October 13th 2011

RE: Hoff Short Plat SP-11-00010 **Revised Comment**

James Rivard,
Environmental Health Supervisor
Kittitas County Public Health Department

HOFF SHORT PLAT
PART OF SECTION 9, T. 18 N., R. 17 E., W.M.
KITITAS COUNTY, WASHINGTON

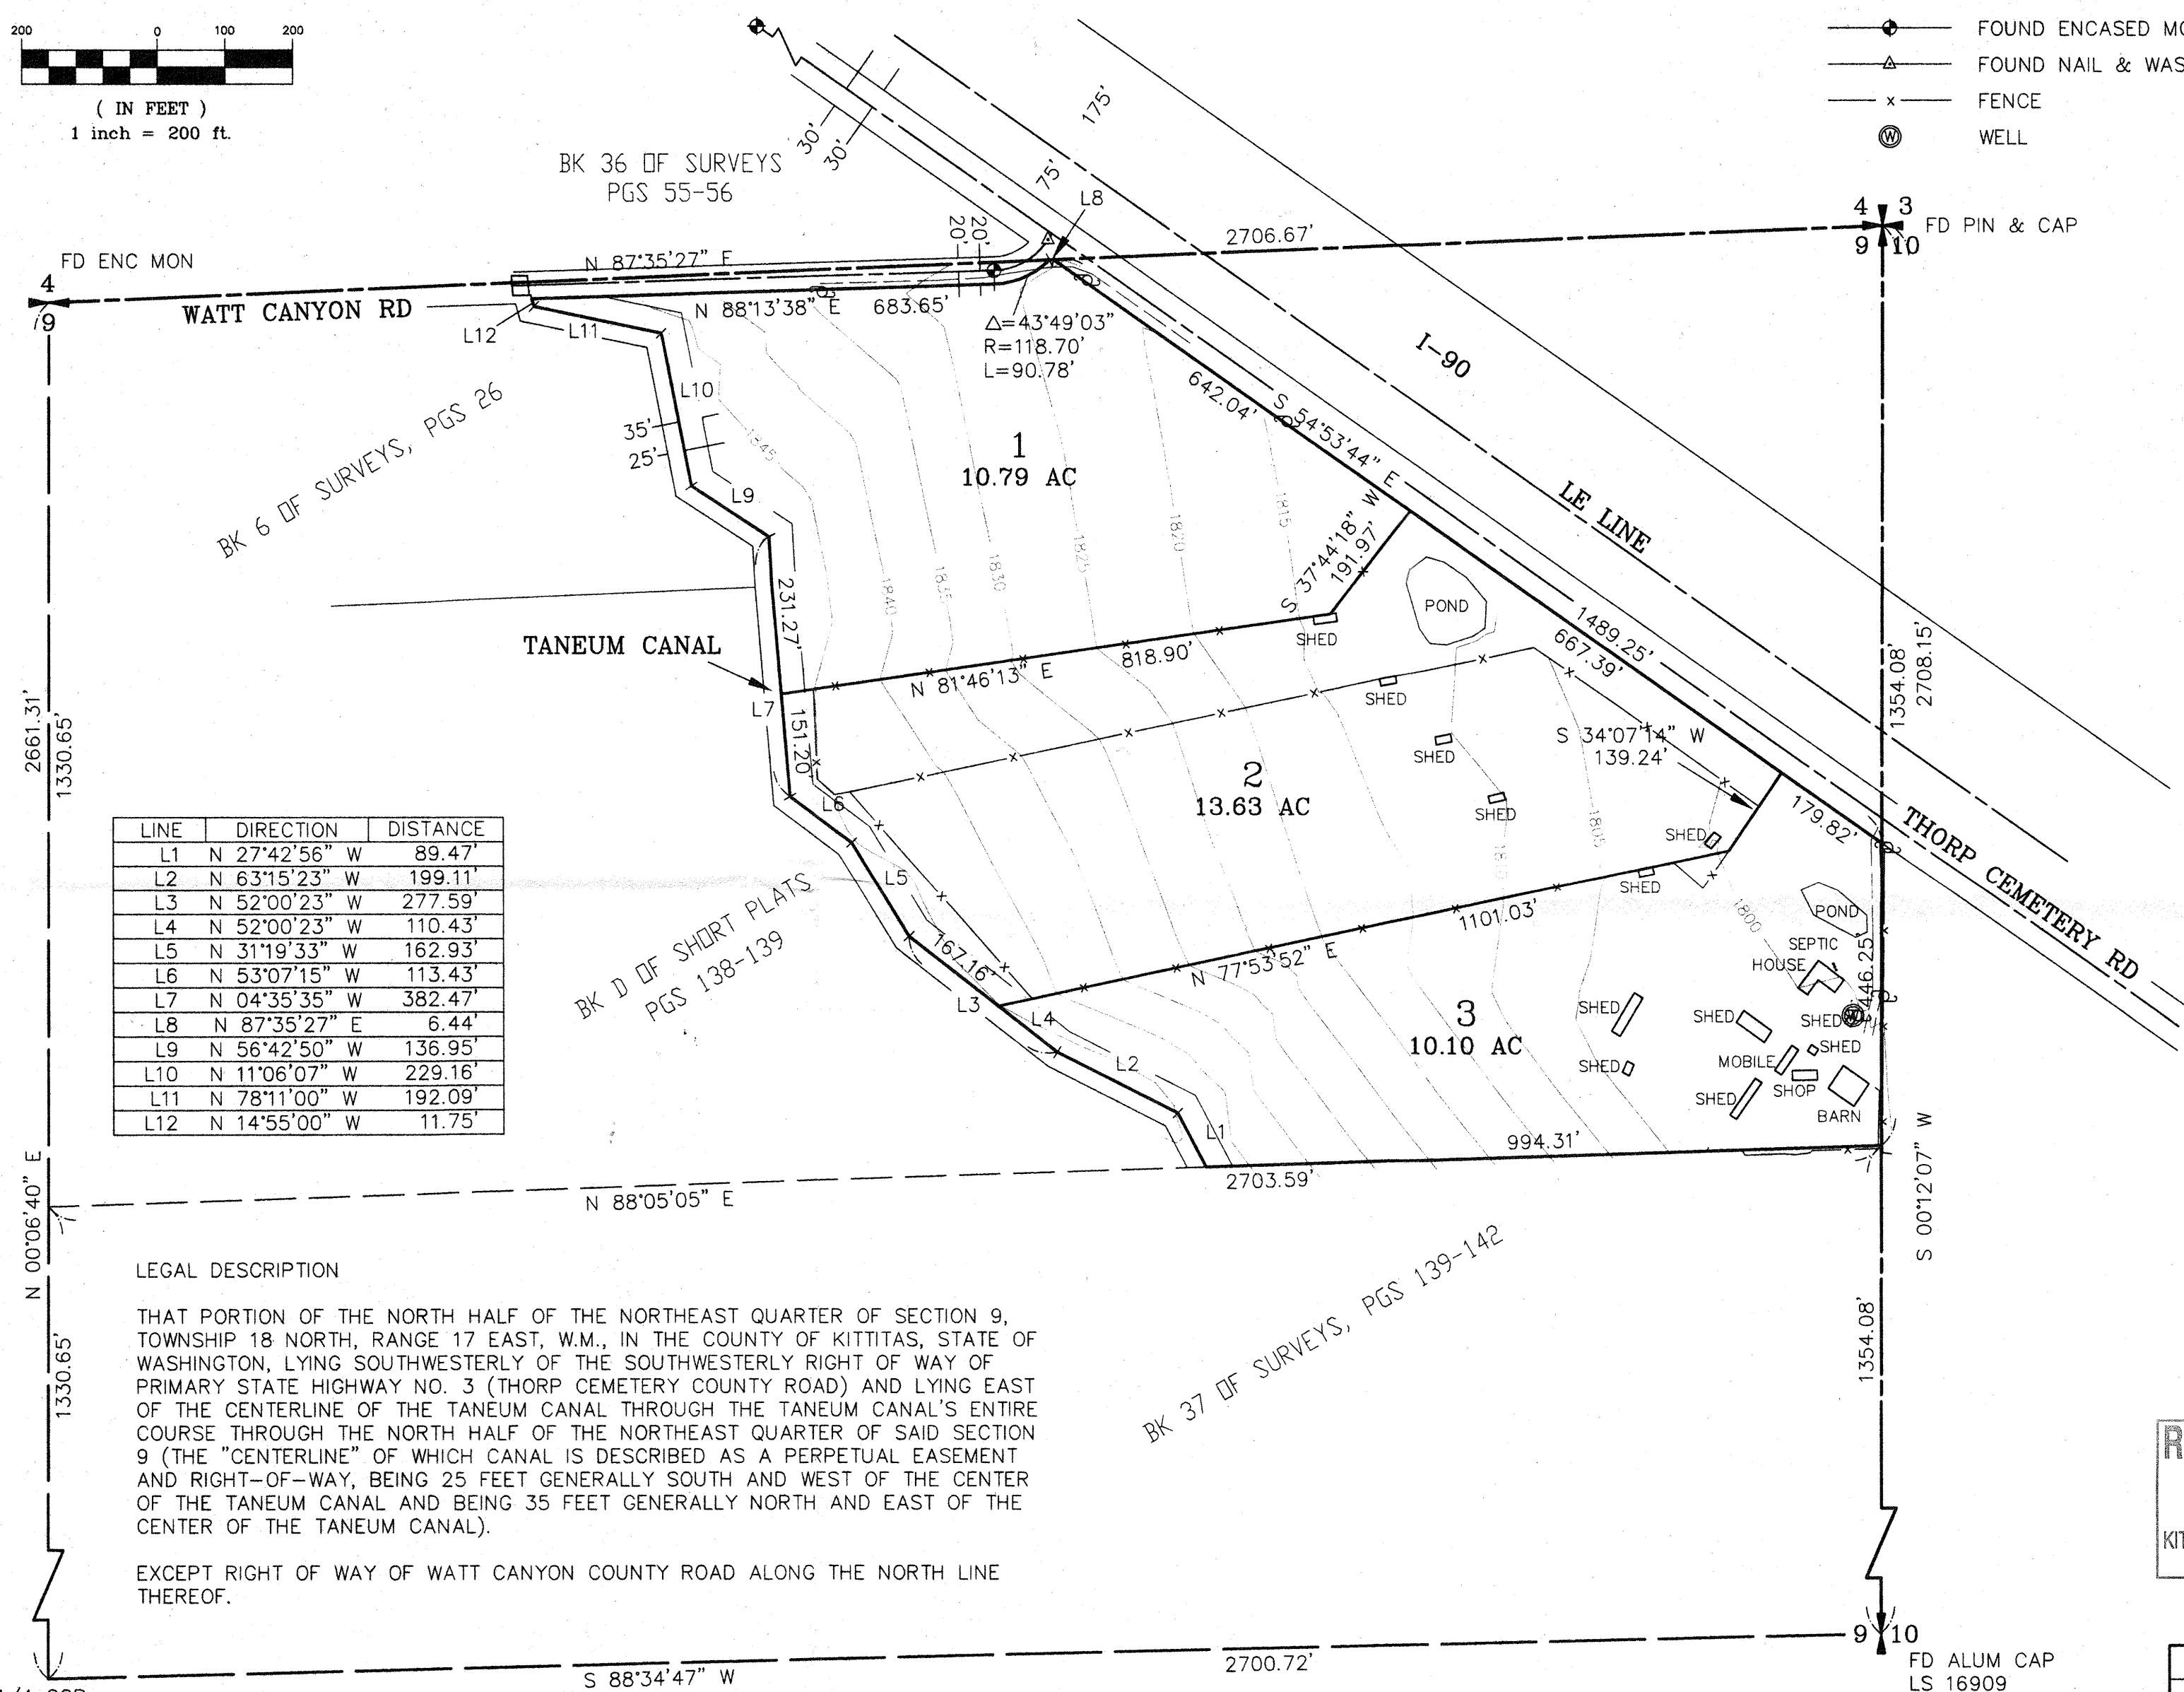
In addition to this information our office is requesting additional information regarding the septic system(s) currently on site. Our department would like to know the type, size, age, location on site and the distance to any septic tank or drainfield(s) and the existing well. Depending on the circumstances our office may have additional requirements.

Parcel #3 will also need to have a recorded shared well user's agreement before plat approval.
